Date: 15-Apr-2024  
Our Ref: 2024/90565

**TOWN AND COUNTRY PLANNING ACT 1990  
TOWN AND COUNTRY PLANNING (GENERAL PERMITTED DEVELOPMENT) (ENGLAND)  
ORDER 2015 – SCHEDULE 2, PART 1, CLASS A.1 (g)  
AT: 70, Bywell Road, Dewsbury, WF12 7LH  
Prior notification for single storey rear extension**

The Authority has considered your application and it has been determined that the proposal is not acceptable and prior approval is hereby **Refused** for the following reason(s);

DRAWING REF: REV:
23292-D02-A

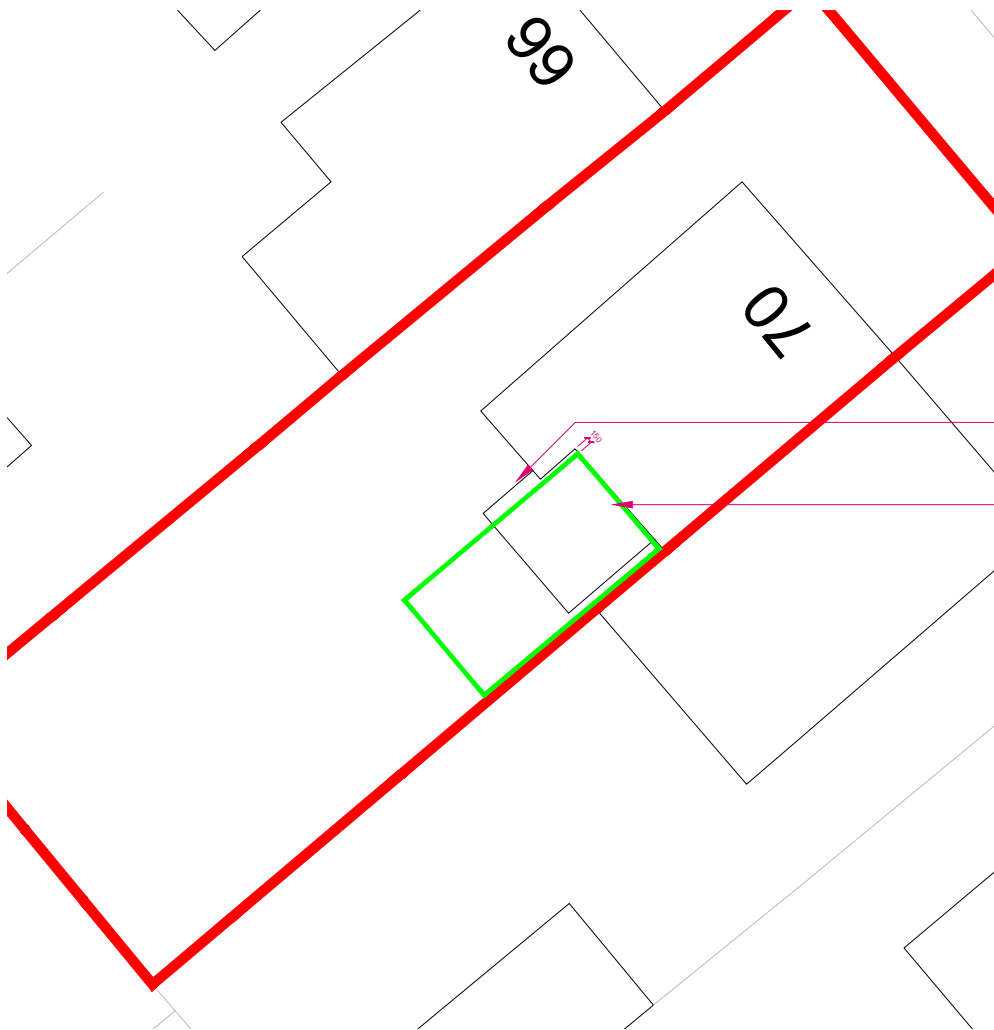
The proposed enlargement cannot benefit from a general planning permission under Article 3(1) and Schedule 2, Class A, Part 1 of the Town and Country (General Permitted Development)(England) Order 2015(as amended) as it consists of an enlargement which projects beyond a side elevation of the original dwellinghouse and has a width more than half the width of the original dwellinghouse contrary to sub-paragraph (j) of Class A.
